**SEAS DEADLINE 6 RESPONSE to APPLICANTS's SUBMISSIONS**  
**SINCE DEADLINE 5, ISH3, Action Points and ExQ3**  
**LANDSCAPE & VISUAL and CULTURAL HERITAGE**

**PINS Ref:** EN020026  
**DEADLINE 6:** APRIL 13, 2026

**RE: SEAS Response to Applicant's Submissions since Deadline 5, ISH3, Action Points and ExQ3 – Landscape & Visual and Cultural Heritage**

# EN020026 SEA LINK DCO – DL6: RESPONSE BY NICHOLAS BRIDGES

Figure 14. Sea Link EN020026-000343-6.4.2.1 ES Figures Suffolk Landscape and Visual Part 7 of 7, page 7
 CUMULATIVE SCHEMES (MAJOR PROJECTS) SCREENED ZONE OF THEORETICAL VISIBILITY - EAST ANGLIA ONE NORTH AND EAST ANGLIA TWO OFFSHORE WIND FARMS

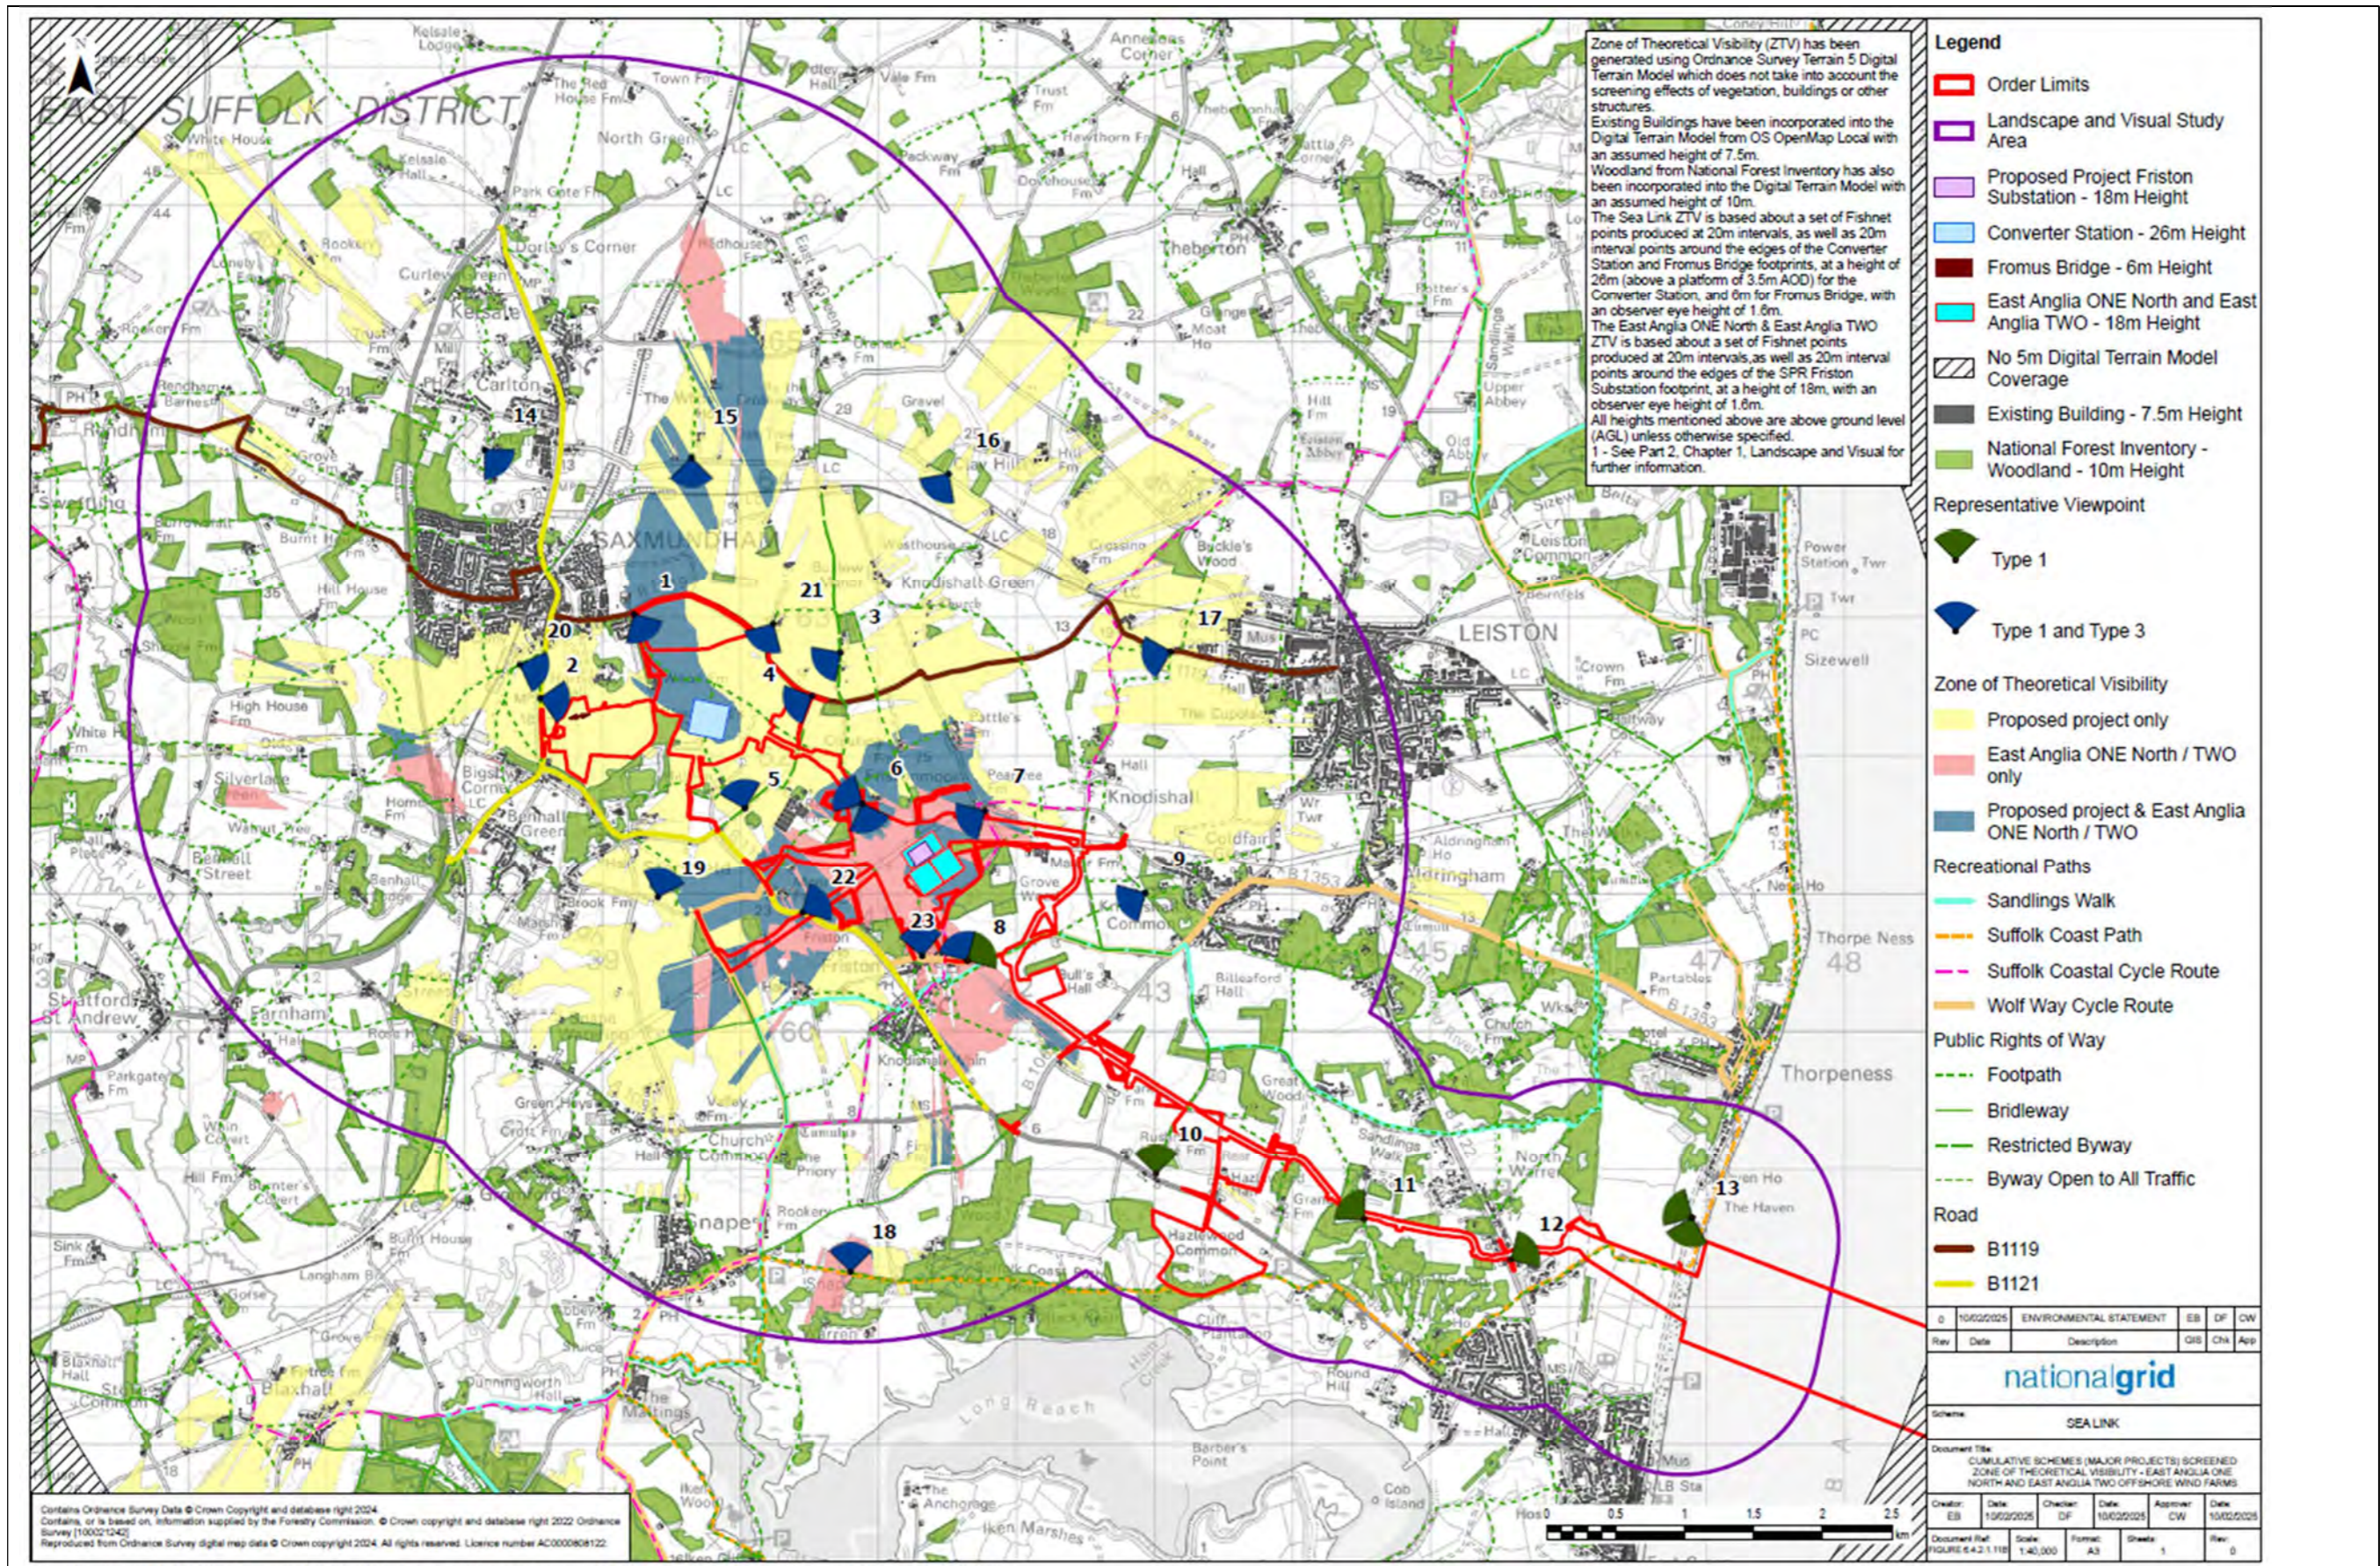
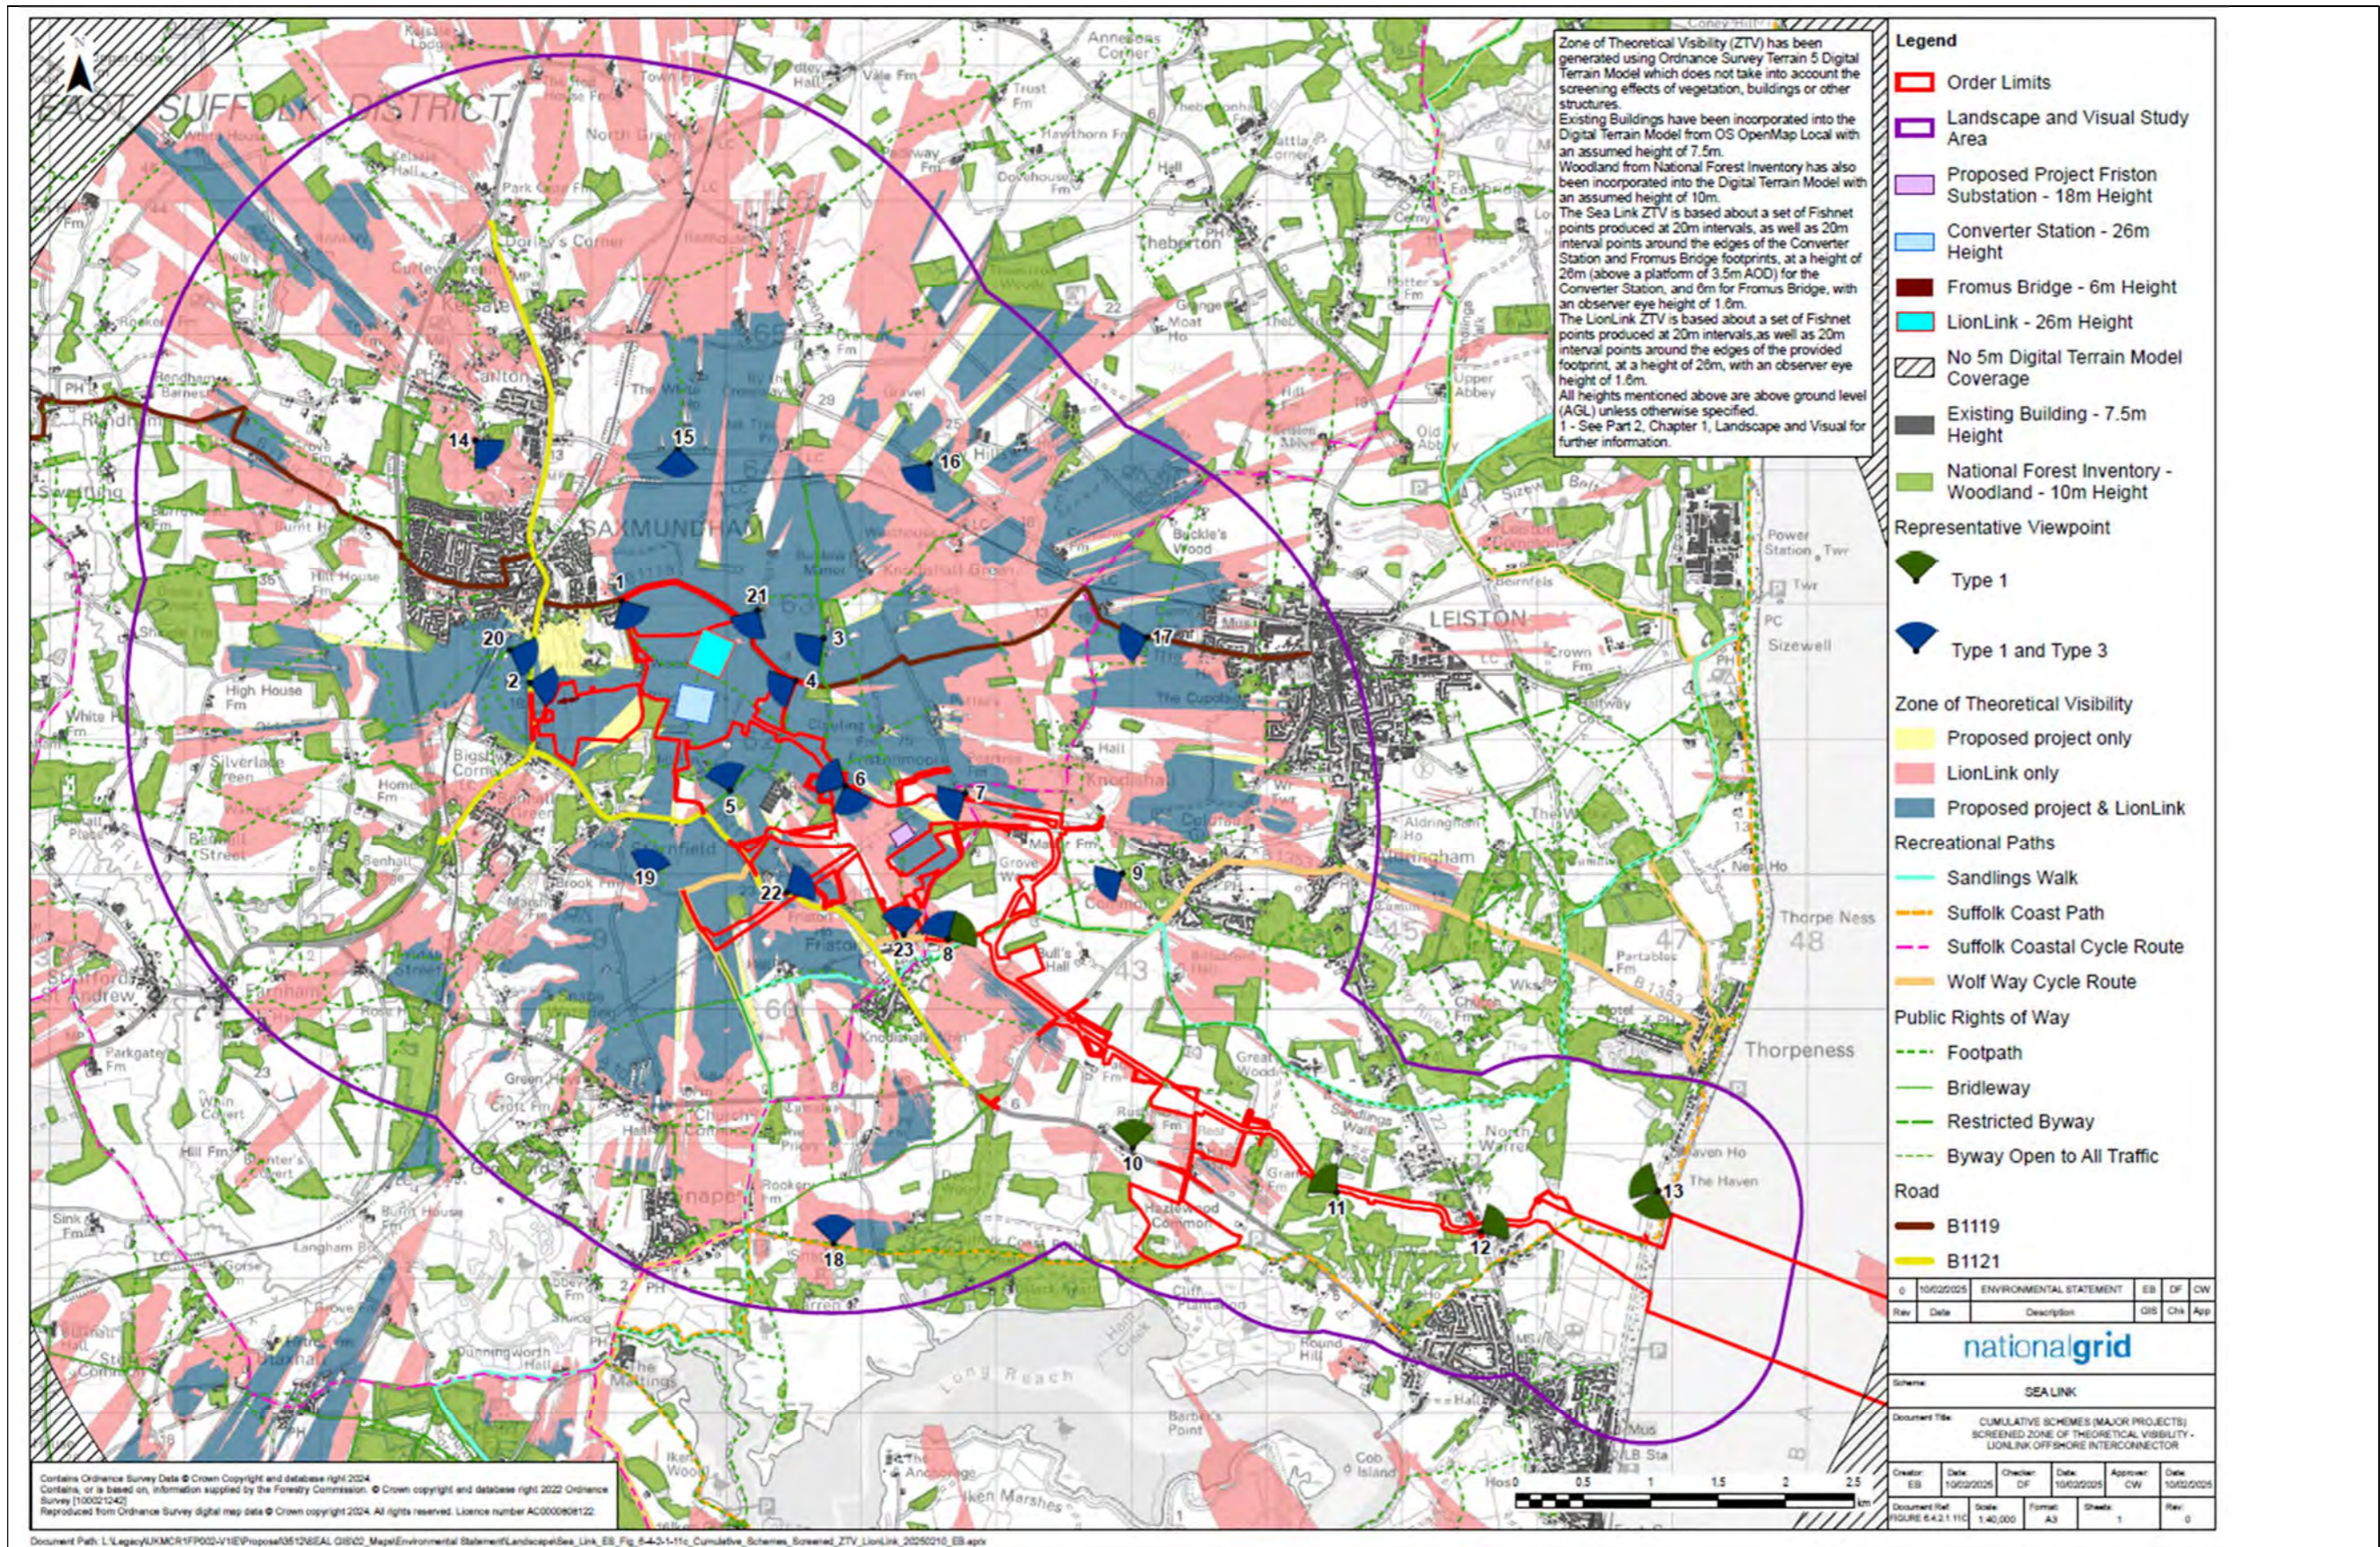
2.10. The 'shadow' patterns illustrate the 'shading' effects of woodland and buildings. The ZTV plans of the same proposed volumetric parameters (**Figures 12 to 17** below) show far less visibility than its PEIR ZTV plans. The accompanying textual details of the model's constraints are exactly the same (see the schedule below).

- 3.3. Are the ZTV plans for EA1N and EA2 correct.
- 3.4. There has been and is sufficient evidence available to warrant further understanding of the visibility of the proposed project on the south side of the Alde estuary.
